An
Coimisiún
Pleanála

Inspector's Report

ACP-323433-25

Development	Section 146B request to alter the previously permitted replacement of existing biomass-fired boilers, biomass-fired thermal fluid heater and gas-fired thermal fluid heater at Medite's manufacturing plant (ABP-319013-24),
Location	Redmondstown, Clonmel, County Tipperary
Planning Authority	Tipperary County Council
Requester	Medite Europe DAC
Type of Application	Application under Section 146B of the Planning and Development Act, 2000 (as amended) to alter previously approved Strategic Infrastructure Development.
Date of Site Inspection	Not required
Inspector	Liam Bowe

C

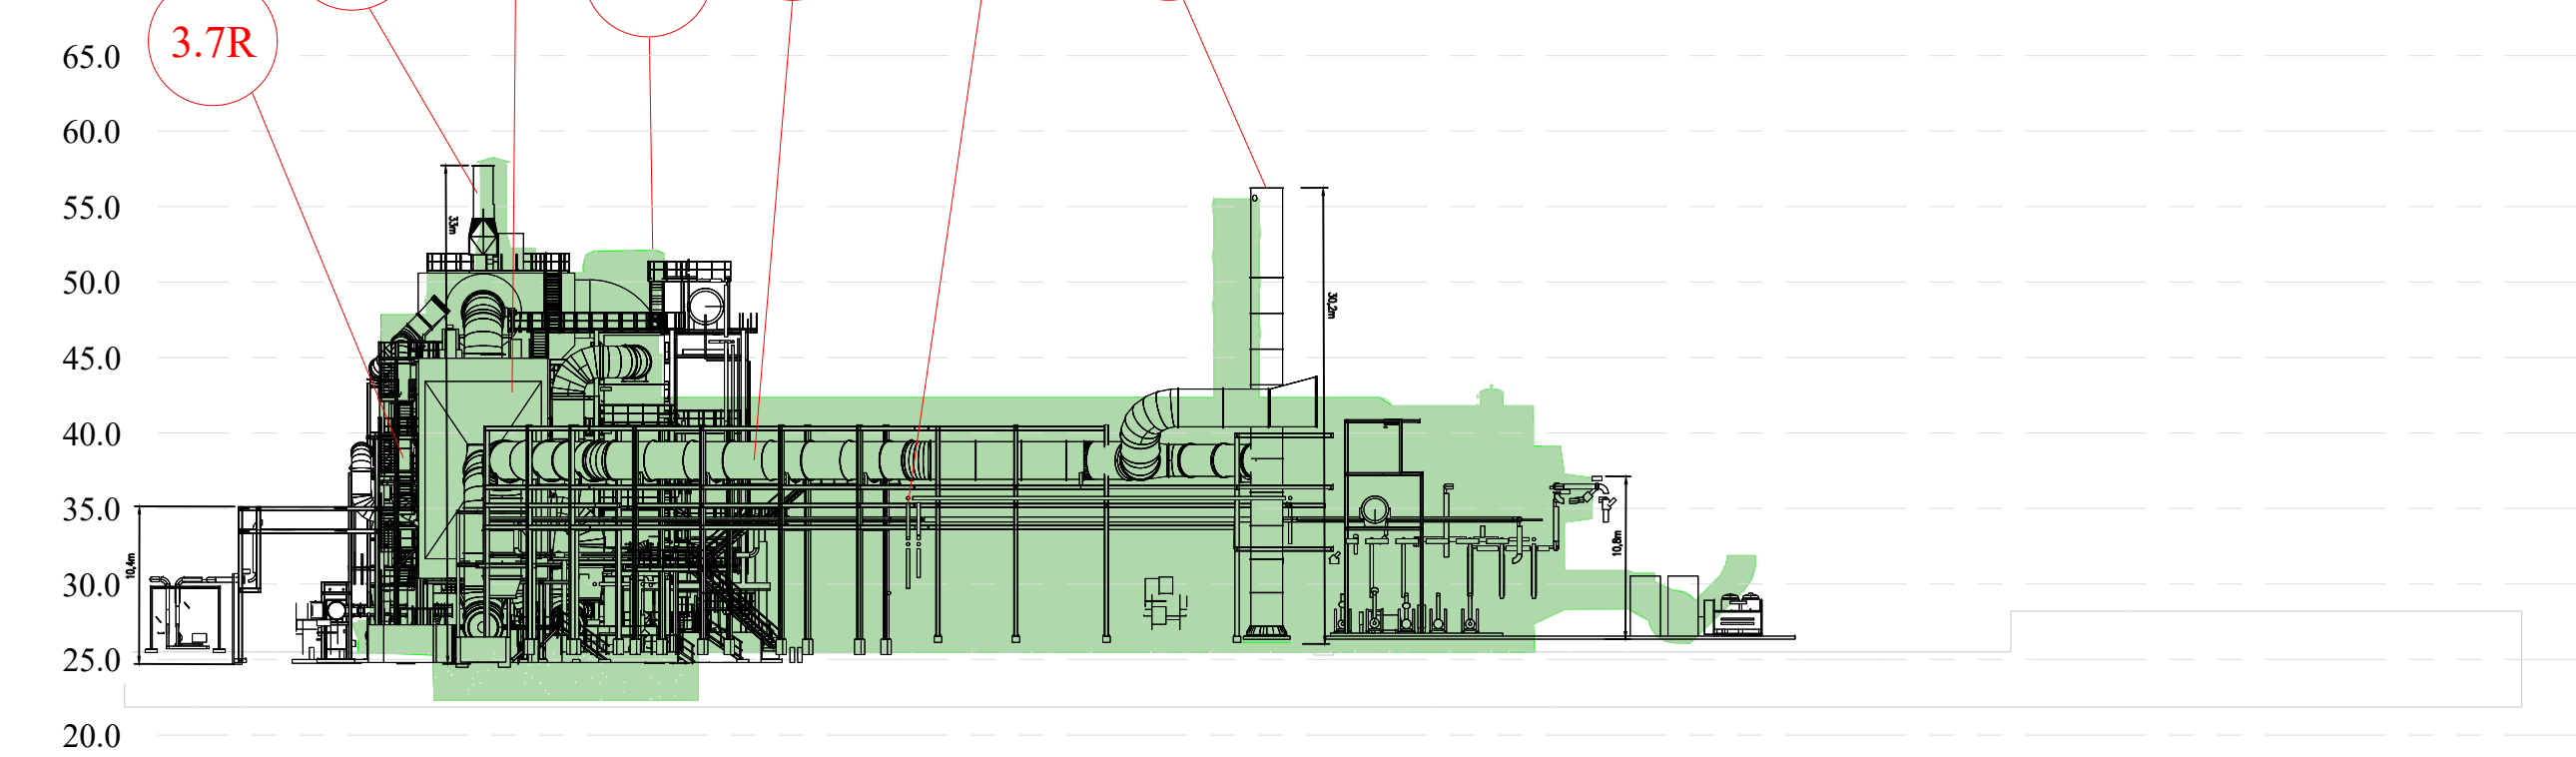
Table 2: Proposed alterations within Development Area 2

Item No.	Permitted Item	Proposed Item
3.1	Line 1 Wet Fuel Metering Bin 18.6m x 15.7m x 4.5mH Area = 292.0m ²	Line 1 Wet Fuel Metering Bin 28.8m 7.4m x 10.3mH Area = 213.1m ²

3.2	Line 1 Energy System Fuel Feed Conveyor 33.2m L x 1.1m W Max Height 17.8m Area = 38.0m ²	Line 1 Energy System Fuel Feed Conveyor 31.4m L x 1.0m W Max Height 20.7m Area: 31.4m ²

3.3	Line 1 Energy Plant 32.5m x 21.6m x 33m Area = 702m ²	Line 1 Energy Plant 28.2m x 21.0m x 33mH Area: 592.2m ²
3.4	Line 1 Dry Electrostatic Precipitator 27.6m x 13.7m x 23.3mH Area = 286.9 m ²	Line 1 Dry Electrostatic Precipitator 24.5m x 11.1m x 23.3mH Area = 271.9m ²

3.5	Line 1 Hot Gas Duct 105m long x Ø3.2m Area = 336.0m ²	Line 1 Hot Gas Duct 98.1m long x Ø2.6m Area: 255.0m ²
3.6	Line 1 Start Up Stack 30.2mH x Ø3.6m Area = 10.8m ²	Line 1 Start Up Stack 30.2mH x Ø2.7m Area: 9.0m ²

3.7	Line 1 Sander Dust Silo Ø 6.0m x 16mH Area = 28.3m ²	Line 1 Sander Dust Silo Ø 3.0m x 13.3mH Area: 9.0m ²
3.8	Line 1 Thermal Fluid Piping 217m L x Ø 0.6m x 16.3mH Area = 130.2 m ²	Line 1 Thermal Fluid Piping 107.1m L x Ø 0.3m x 10.3mH Area: 32.1 m ²

3.9	Line 1 Steam Generator 14.4m x 3.5m x 17.9mH Area = 47.5m ²	Line 1 Steam Generator 13.5m x 4.4m x 10.8mH Area: 59.4m ²
3.10	Line 1 Dryer System 34.0m x 17.5m x 13.9mH Area = 505.7m ²	Line 1 Dryer System 34.0m x 17.5m x 13.9mH Area = 505.7m ²
3.11	Line 1 Bunded Oil Storage 10.4m x 6.4m x 3.1mH Area = 66.5m ²	Line 1 Bunded Oil Storage 10.5m x 6.9m x 3.9mH Area: 72.5m ²
